From: Laura Gibbons <Laura.Gibbons@arun.gov.uk>
Sent: 20 October 2020 15:16
To: Planning.Responses <Planning.Responses@arun.gov.uk>
Cc: Raymond Cole <Raymond.Cole@arun.gov.uk>

Thank you for consulting us we have the following comments on Flood Risk and Surface Water Drainage

Part D: Drainage Strategy Overview

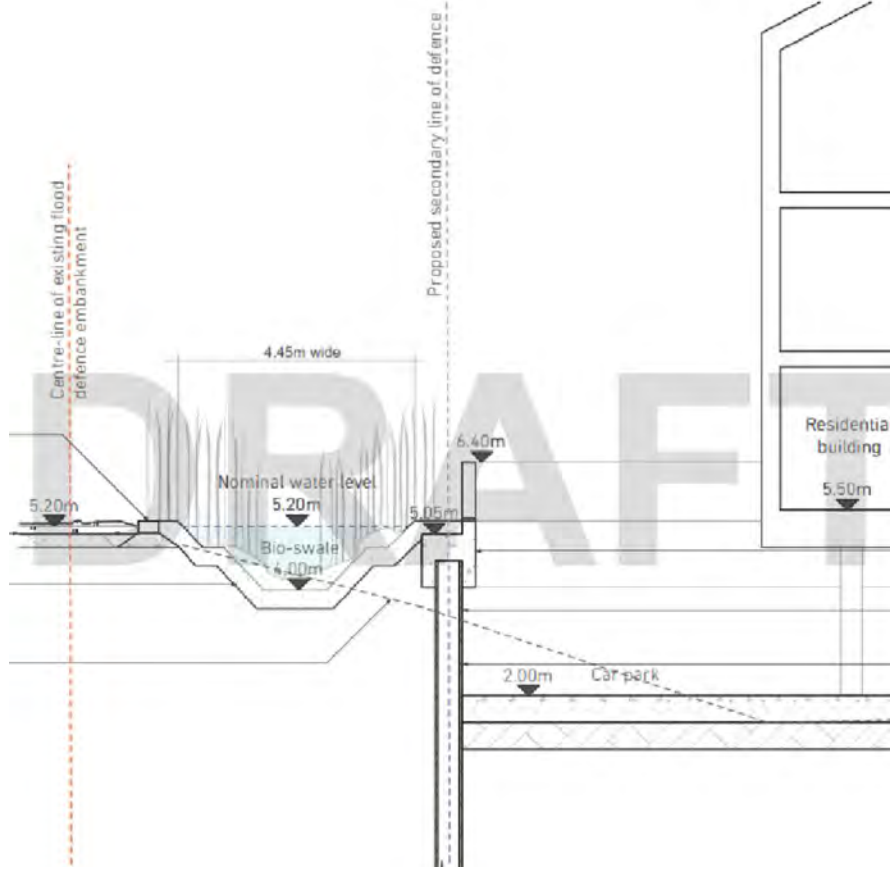
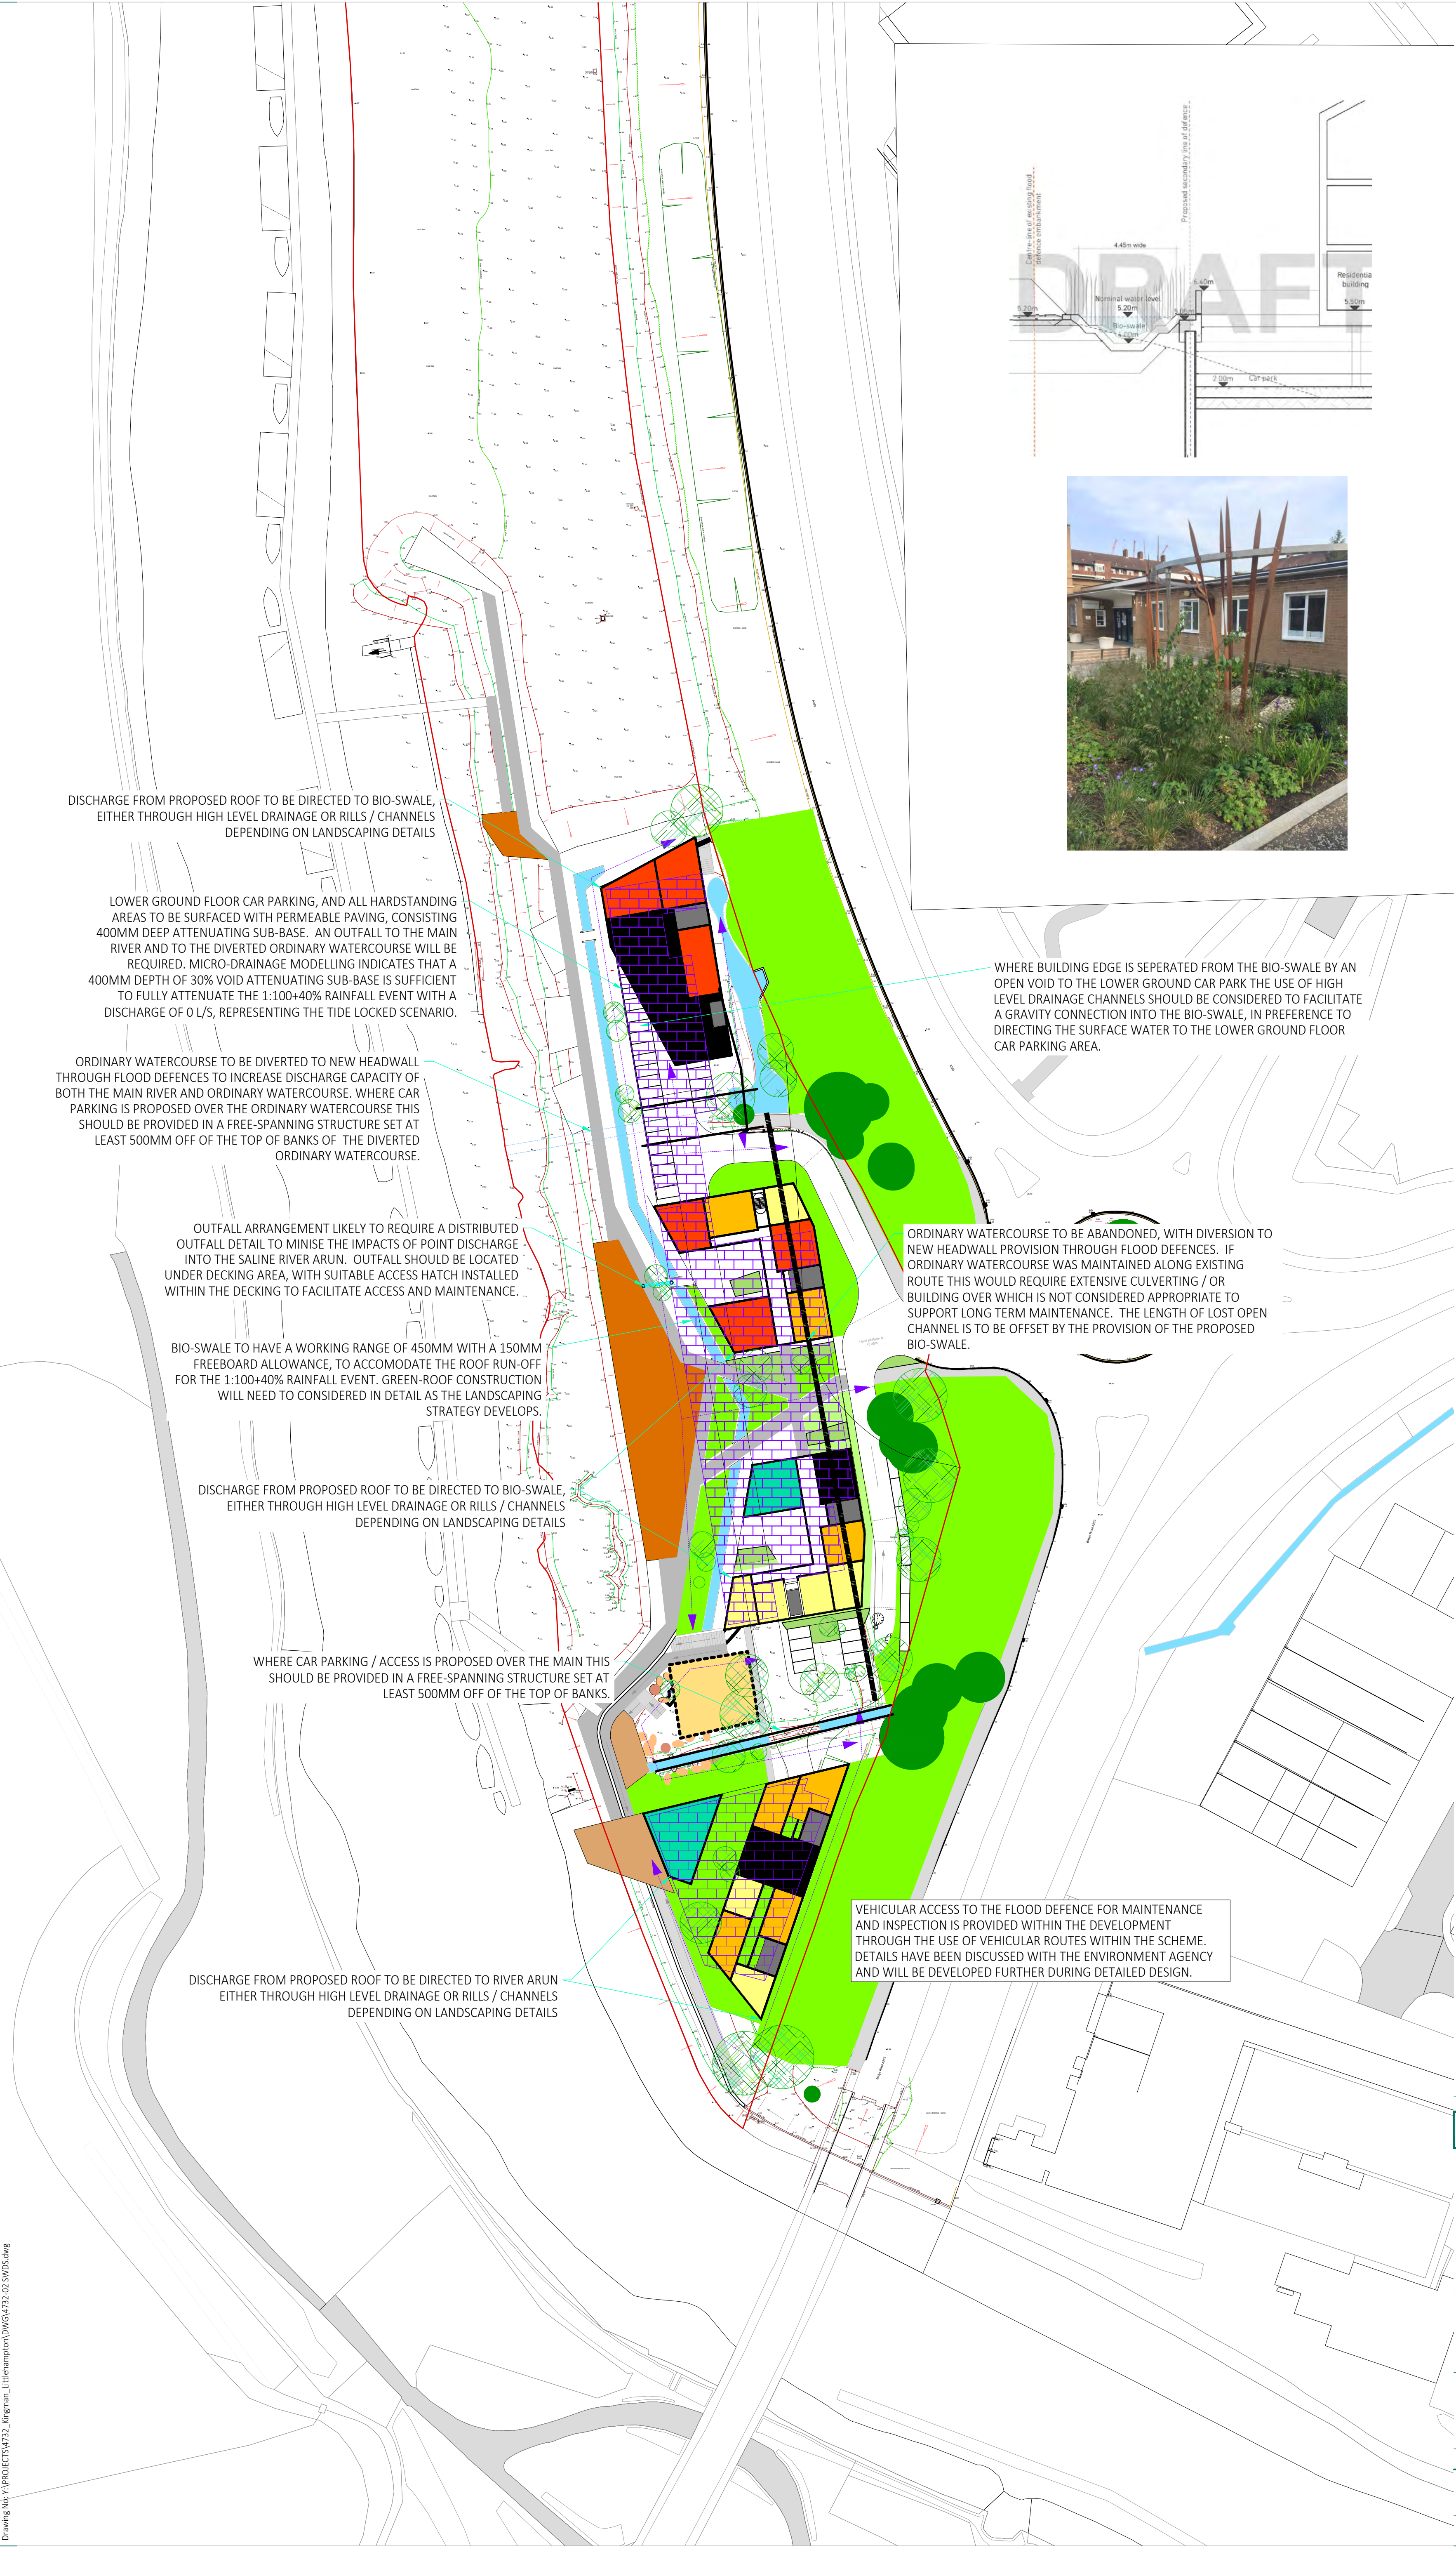
The proposals include infilling/ diversion of ordinary watercourse. Land drainage consent will be required for such activities. A buffer of 3m must be provided between top of bank of watercourses and proposed structures that will limit access.

Uncontrolled discharge to tidal bodies is acceptable. However, the impact of tidal locking on outfalls must be considered. Therefore, if proposals are to discharge to the tidal body it is highly likely that storage will be required to ensure that the surface water does not flood the site during high tide. We note that the strategy submitted proposes a bio swale to convey the discharge of roof water and permeable paving to store water from paving areas prior to discharge to main river or ordinary watercourse. If discharge is proposed to watercourses that are the landward side of defences then it will be necessary for discharge to be limited to QBar or 2l/s whichever is greater. Full calculations, layout plans, and construction details will be required to support design.

Calculations for surface water drainage should use FEH data, or if FSR is used Cv must be set to 1.

It is noted that infiltration has been ruled out based on BGS data. Winter infiltration testing must be completed on site to establish if infiltration is viable. Detailed design should be supported by winter groundwater monitoring. Winter groundwater monitoring is required even when infiltration is not proposed to ensure that the effects of flotation are adequately accounted for in design.
